6 November 2013

Name: Khwanrat Chatjaroenporn
Address: 388 Abercrombie St.
Darlington, NSW 2008

**Modification Request for the University of Sydney Abercrombie Precinct
Redevelopment: Application Number: MP07_0158 MOD 3**

Title
Scale
Date
Number
0 2 4
10 20m
Ground Floor Plan
MARK UP SET
1:200@A1
11.10.13
4001_DA02-D
© copyright nettleton tribe partnership pty ltd

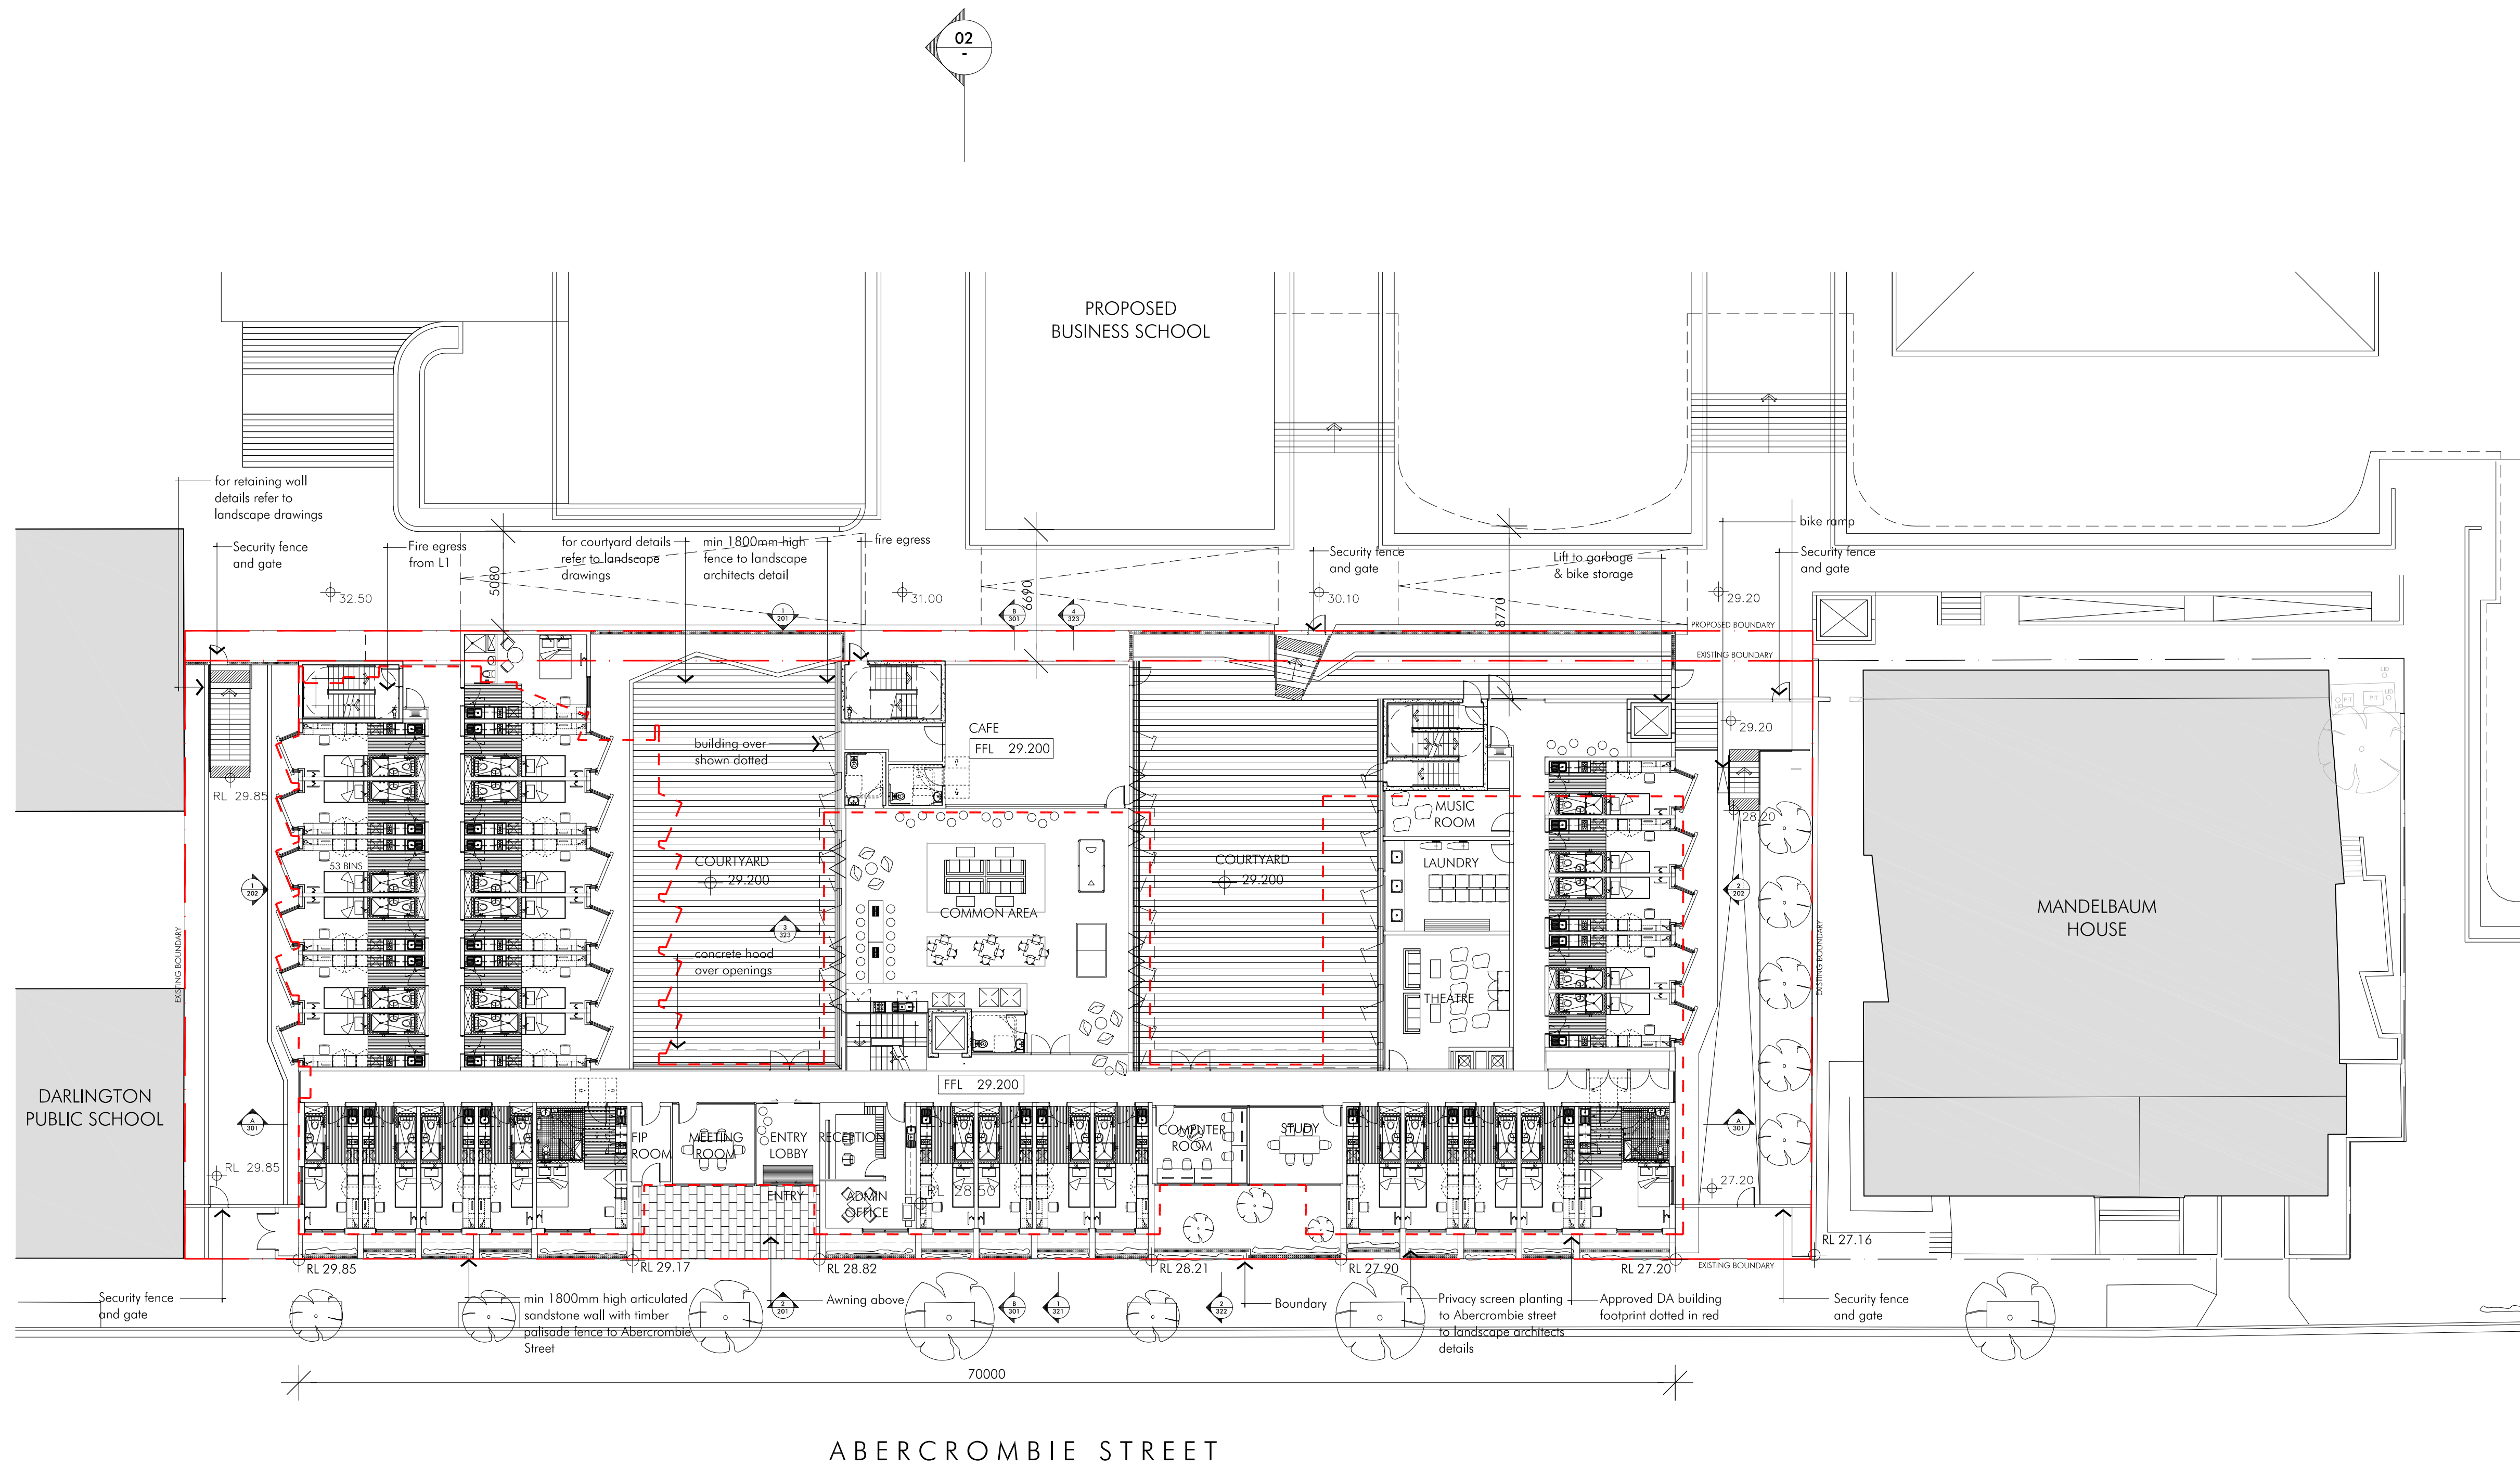
- The front of the Student Accommodation building should be built 2 metres back from the Abercrombie Street boundary. It should be set back from this boundary so that it is in line with Mandelbaum House as it was originally planned and presented to the community. The footprint of the buildings currently on the site, The Shepherd Centre and Boundary Lane Children's Centre, were built approximately 2 metres back from the Abercrombie Street boundary and align with Mandelbaum house. Therefore, the front footprint of the proposed Student Accommodation building should be the same as those buildings occupying the site at present and not be built up to the Abercrombie street boundary.

- The facade of the proposed Student Accommodation building does not reflect the heritage appearance of the Victorian terraces on Abercrombie Street as Mandelbaum House does. Therefore, it should be set back to allow for extensive vegetation and trees to be planted in front of the building on Abercrombie Street to help preserve the heritage streetscape and improve both the aesthetics and the environment of the street.
